From: Amanda Scholes on behalf of Planning.Responses
Sent: 17 June 2020 08:14
To: Planning Scanning
Subject: FW: Drainage drawings for Lake Barn site, Maypole Lane - Y/5/20/DOC - UPDATE

Application Ref: Y/5/20/DOC

Subject: RE: Drainage drawings for Lake Barn site, Maypole Lane.

Scale:	Drawn By:	Date:
1:50 @ A2 BC		20/12/'19
Project:	Drawing No.	Revision
MAY01	110/ 09	-

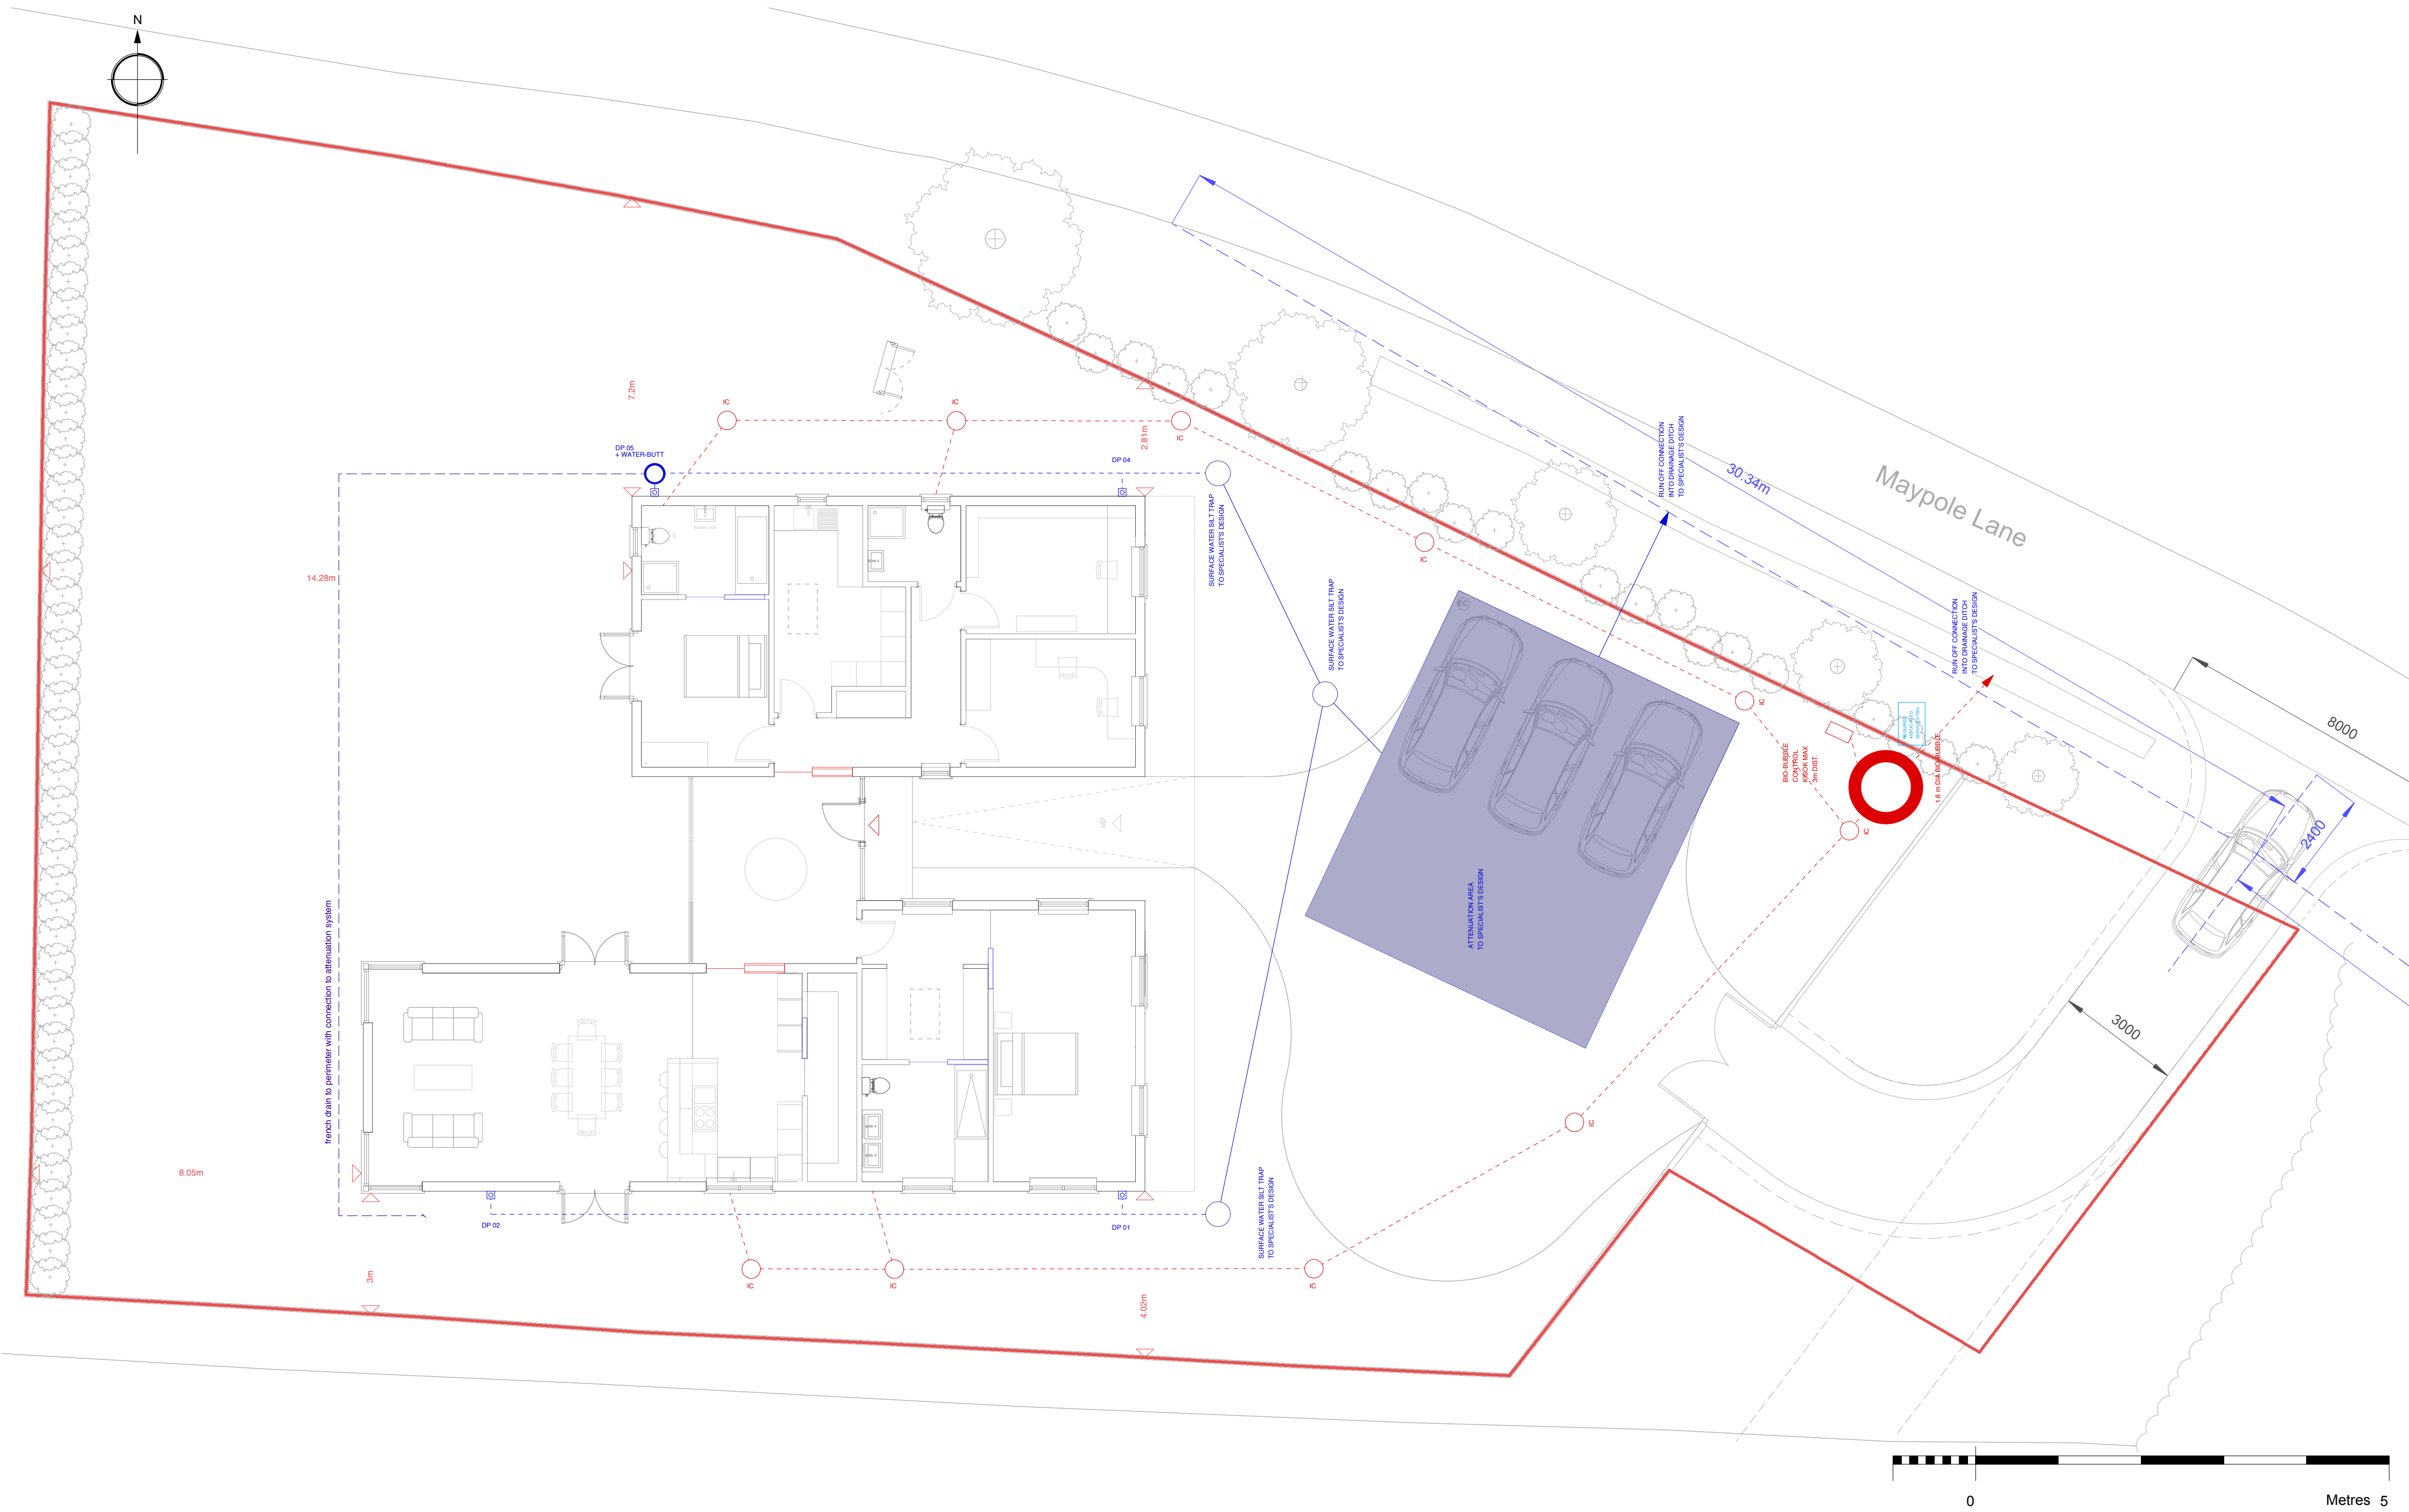
Please note that drawings in respect to plan and land drainage consent need to align with one another.

1. Provide a copy of Rob's most recent report. Rob has emailed this to you directly.
2. Detail 05 and plan – levels downstream of tank need adjusting to achieve a positive fall and both drawings need to correspond with one another in terms of invert levels. This has been updated

3. Specify diameter of catchpit upstream of tank. The more silt capacity the better. This has been updated
4. Clearly indicate the extent of the permeable drive way construction ie. hatch. This has been updated

5. Provide air vent to tank. This has been updated
6. Include pipe bedding details, including concrete or paving slab protection for shallow cover. These have been included

7. Remove RE01 – no need for it. This has been updated
8. Move IC03 eastwards onto join and remove RE02. No bends to be outside manholes. This has been updated

9. Move IC05 south eastwards onto join and remove RE04. No bends to be outside manholes. This has been updated
10. Move IC08 north eastwards onto join and remove RE05. No bends to be outside manholes. This has been updated

11. Move IC09 north westwards onto join and remove RE06. Remove bend between RWP6 and IC09. This has been updated
12. RWP03 – since connection is not being made to a manhole – add note to say it will be connected via a 45 degree oblique junction. This has been updated

Project:
Land Adjacent to Lake Barn, Maypole Lane, Yapton, Arundel,
West Sussex BN19 0DR
Drawing Title:
DRAINAGE
RAINWATER
Drawing Status:
DISCHARGE OF CONDITIONS
APPLICATION

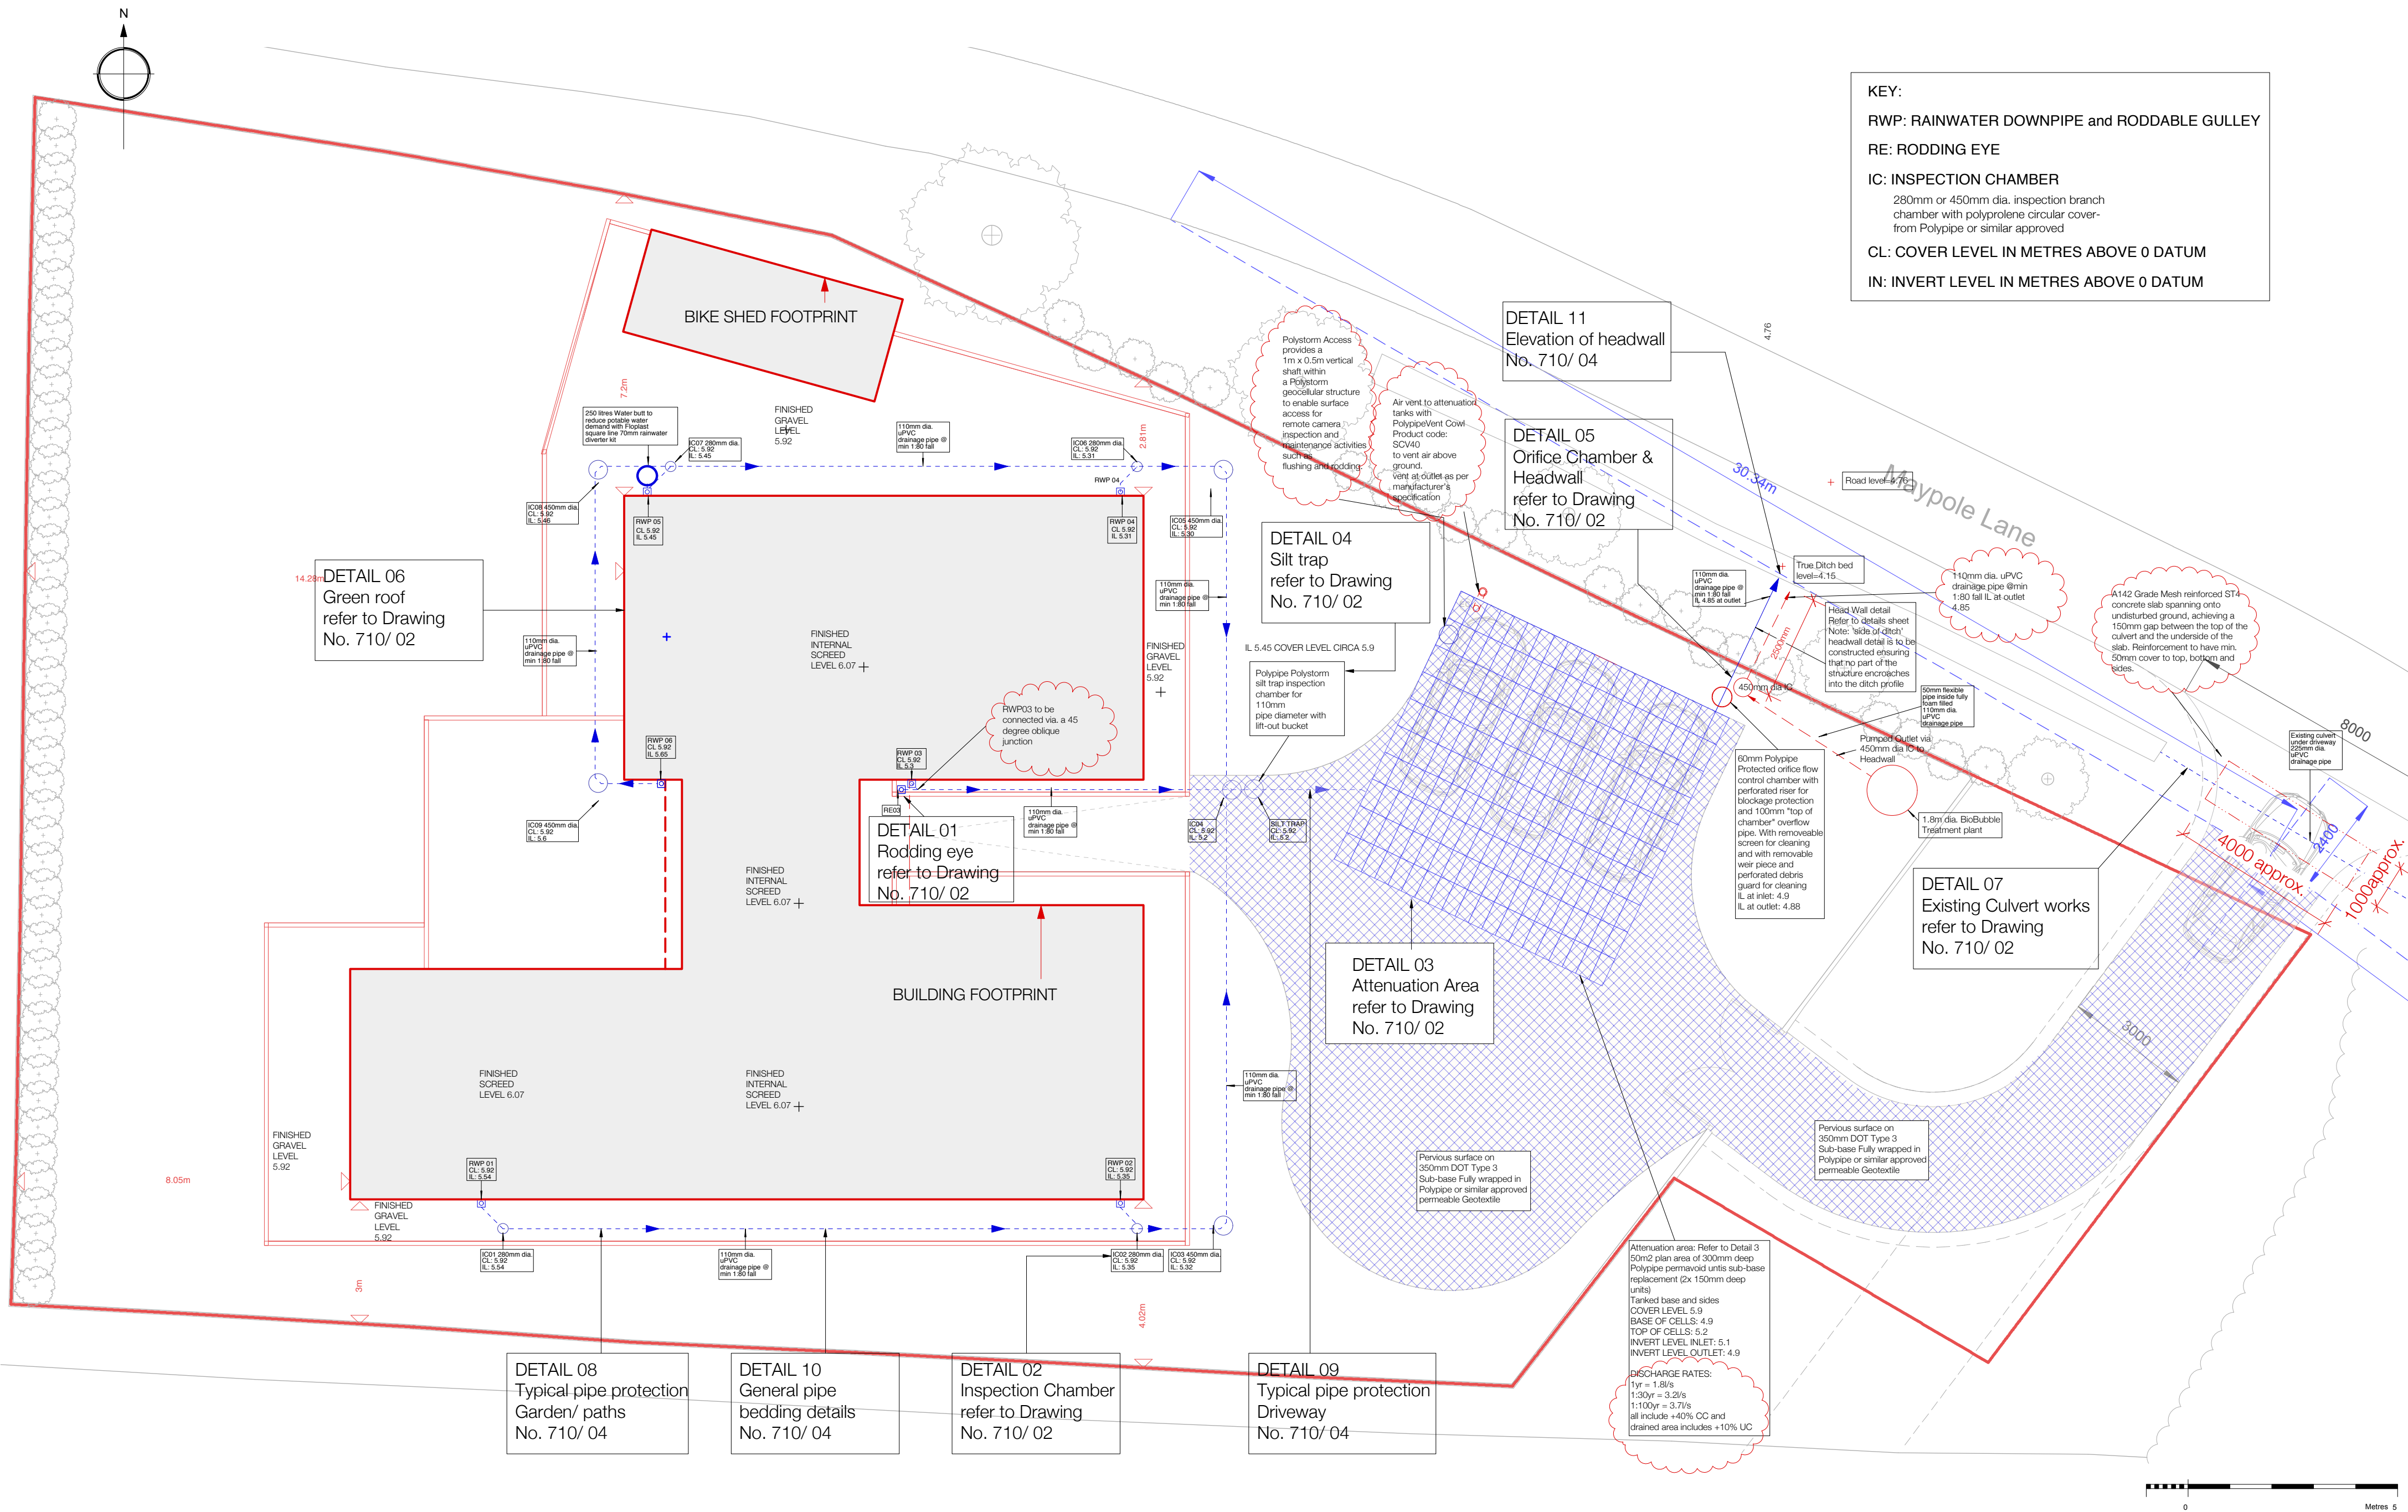
1. The pumped effluent will need to discharge to headwall independently but to the same headwall. The length of gravity pipework downstream of the manhole needs to be along as possible and to be 100mm diameter. Show proposed connection invert level to headwall. This has been updated on the attached drawings.
2. Specify discharge rate from suds system. This has been updated on the attached drawings.
3. Headwall details need to include a dimensioned front elevation. This has been included on the attached drawings.
4. Protection slab to existing culvert detail;
 - a. Specify ST4 concrete
 - b. Reinforcement to have min. 50mm cover (top, bottom and sides)
 - c. Specify grade of mesh
 - d. Permeable geotextile to fully wrap around type 3 stone
 - e. Indicate approx. dimensions of slab length and width.

Please find the attached updated and additional drawings. In addition, I include my response below in blue to your email of the 15th of May.
